**Marine
Management
Organisation**

MMO Reference: DCO/2022/00007
Planning Inspectorate Reference: EN010125
Identification Number: 20050160

Planning Act 2008, RWE Renewables UK Dogger Bank South (West) Ltd and RWE Renewables UK Dogger Bank South (East) Ltd Proposed Dogger Bank South Offshore Wind Farms Order

Deadline 7

Figure: 2.1	Drawing No:	
Co-ordinate system: WGS 1984 UTM Zone 30N	Page Size: A3	Scale: 1:850,000
Project:  Dogger Bank South Offshore Wind Farms	Report:

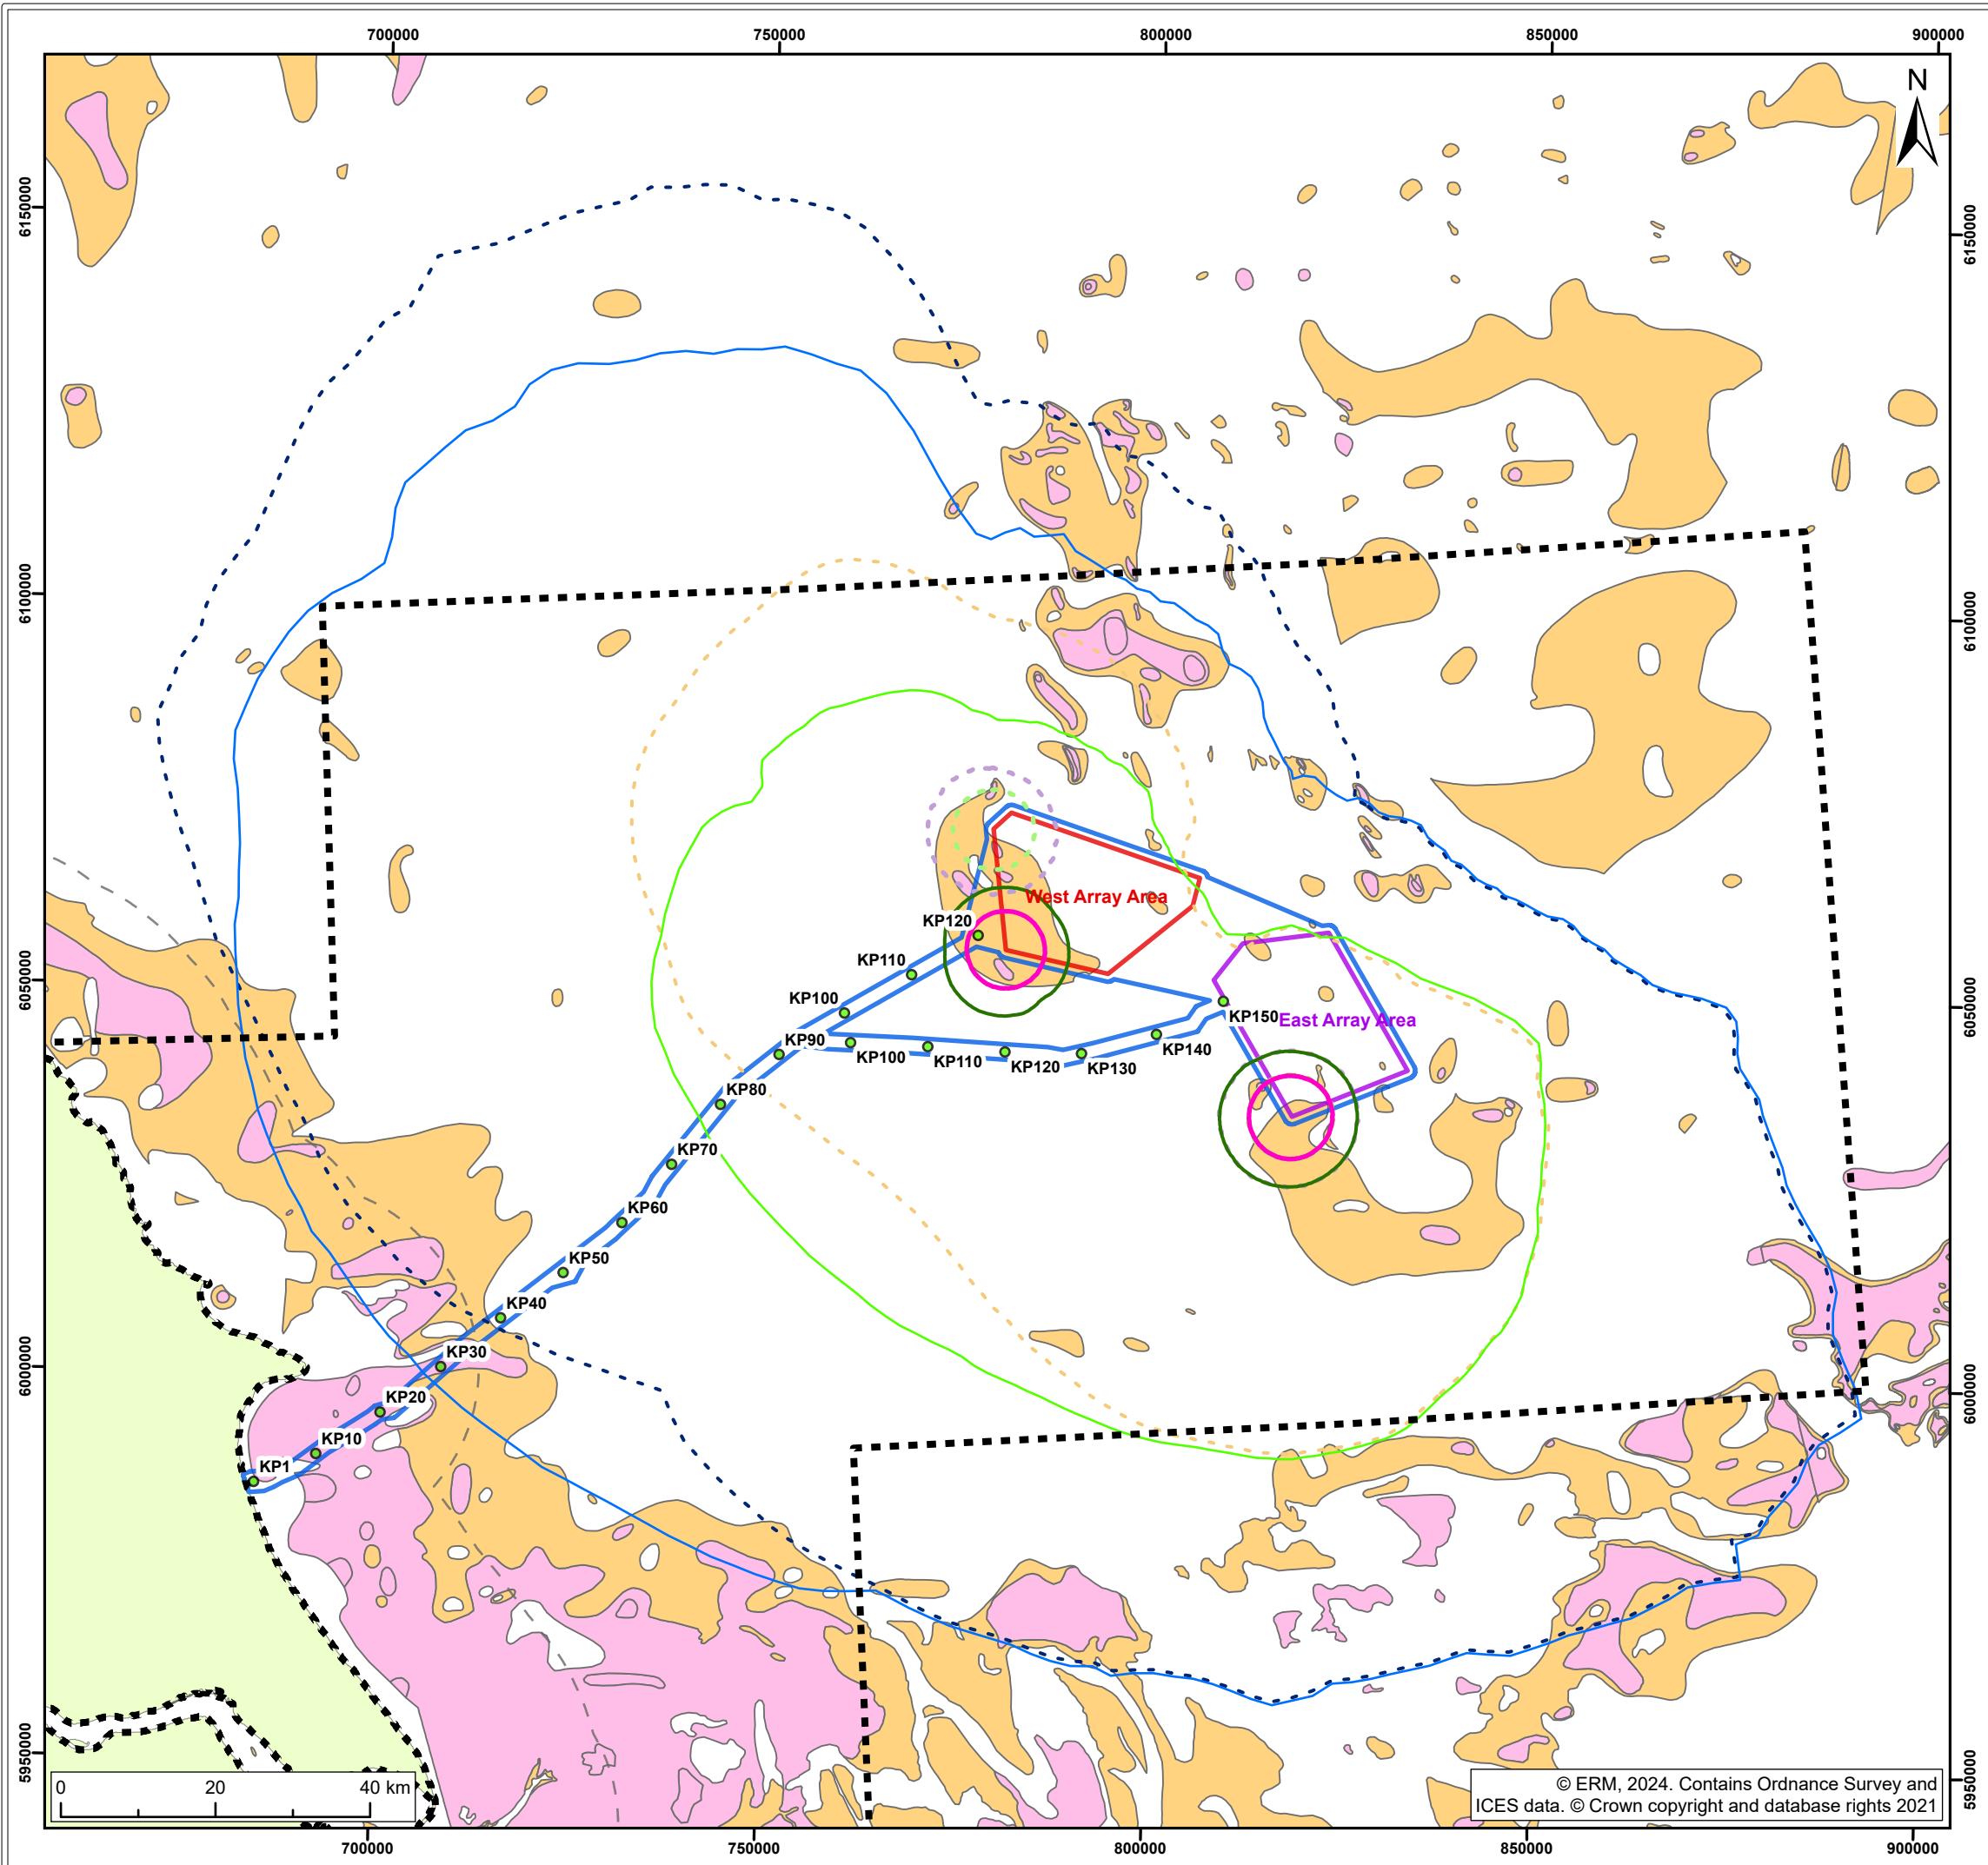
- 2.3.5 In reviewing Figure 2.1 and 2.2 of Document 15.8, the MMO agrees with the Applicants conclusion that amending the DBS West modelling location does not appear to significantly change the impact ranges for physiological effects (as per Popper et al., 2014) with respect to the herring spawning ground. Figure 2.1 does show that amending the DBS West modelling location produces a larger overlap for behavioural effects (as per Hawkins et al., 2014). The additional UWN contour for behavioural effects shows a greater overlap with areas of higher potential spawning habitat than shown by the original modelling location, due to the amended modelling location being further south than the original. This has been acknowledged by the Applicants, and the area of overlap has been quantified as increasing from an UWN overlap of 14.38% with higher potential Atlantic herring spawning habitat (< 0.05 confidence) originally, to an overlap of 30.41% with higher potential spawning habitat.
